City of Albuquerque

May 23, 1986

RE: REVISED DRAINAGE PLAN OF COMMERCIAL BUILDING, 308 MOUNTAIN
ROAD, NE, RECEIVED MAY 22, 1986 FOR CERTIFICATE OF
OCCUPANCY APPROVAL (J-14/D32)

GRADING & DRAINAGE PLAN

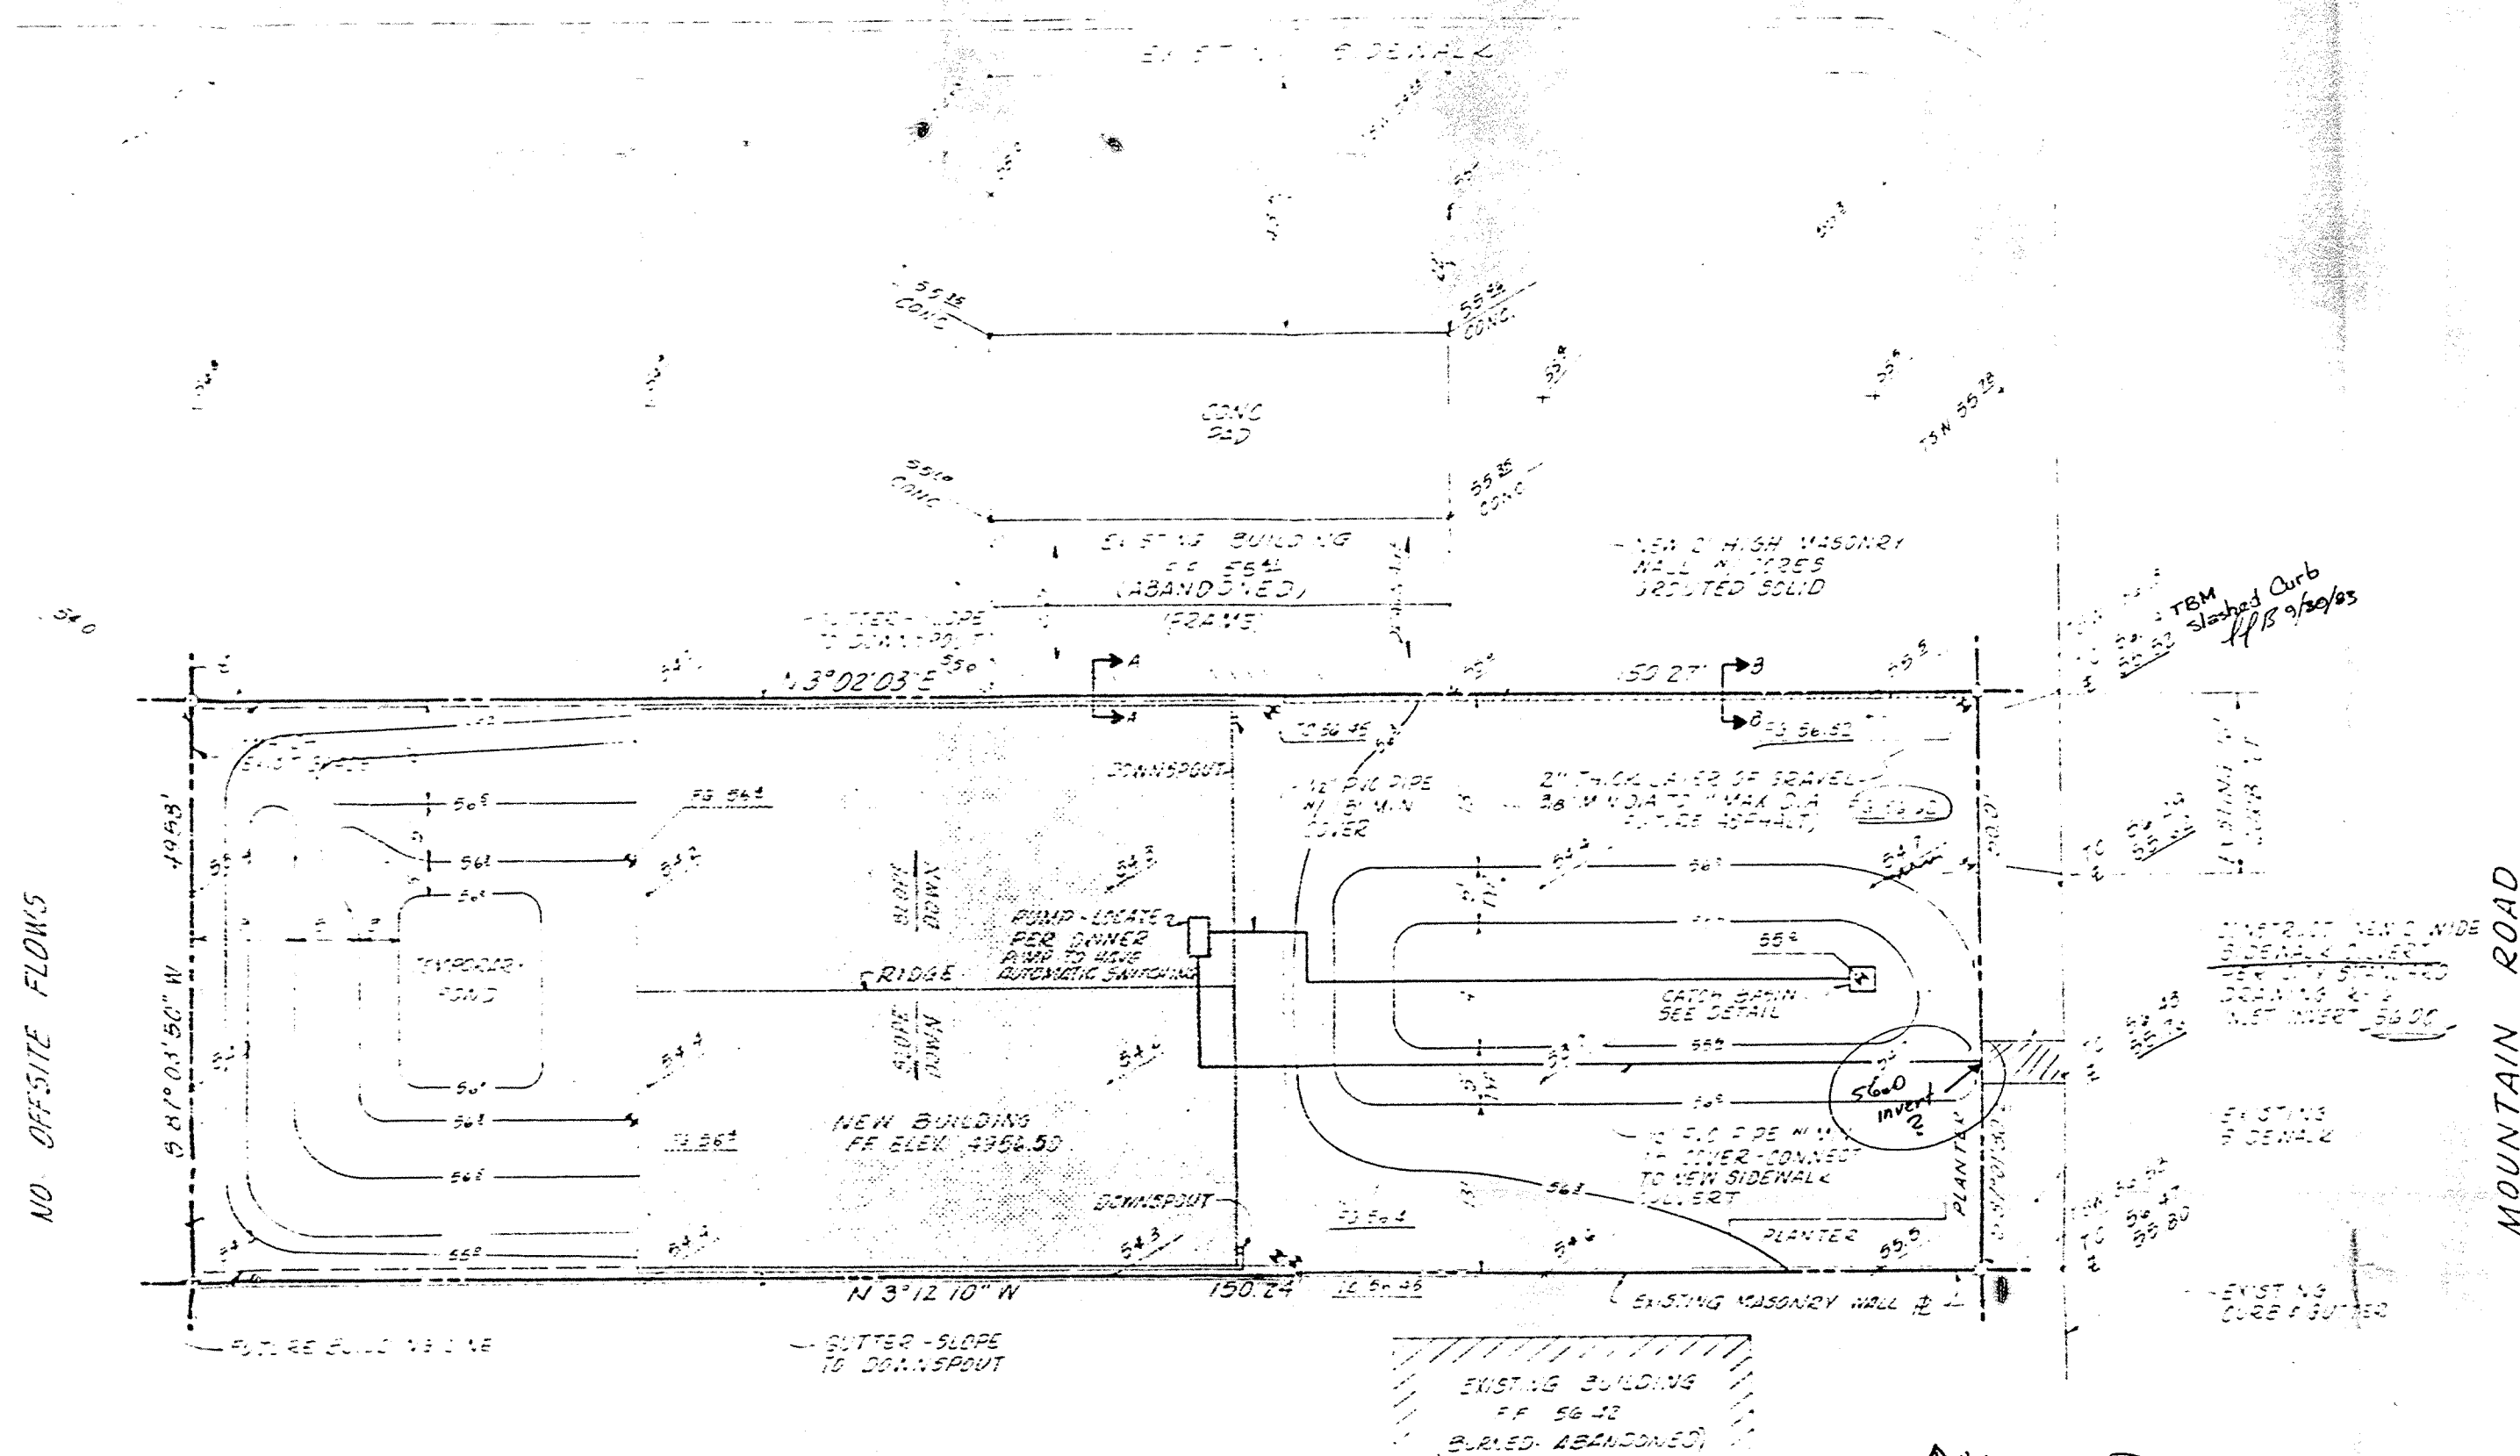
The above referenced submittal, dated May 21, 1986, revising the Grading Plan, dated February 4, 1985, is approved. This approval eliminates the requirement for a fixed permanent sump pump provided all the proposed parking area and sump elevations are constructed as designed. The proposed sidewalk culvert will act as the emergency spillway for the ponding area and outlet for portable sump pump. The landowner will have to provide a portable sump pump to remove ponded storm runoff.
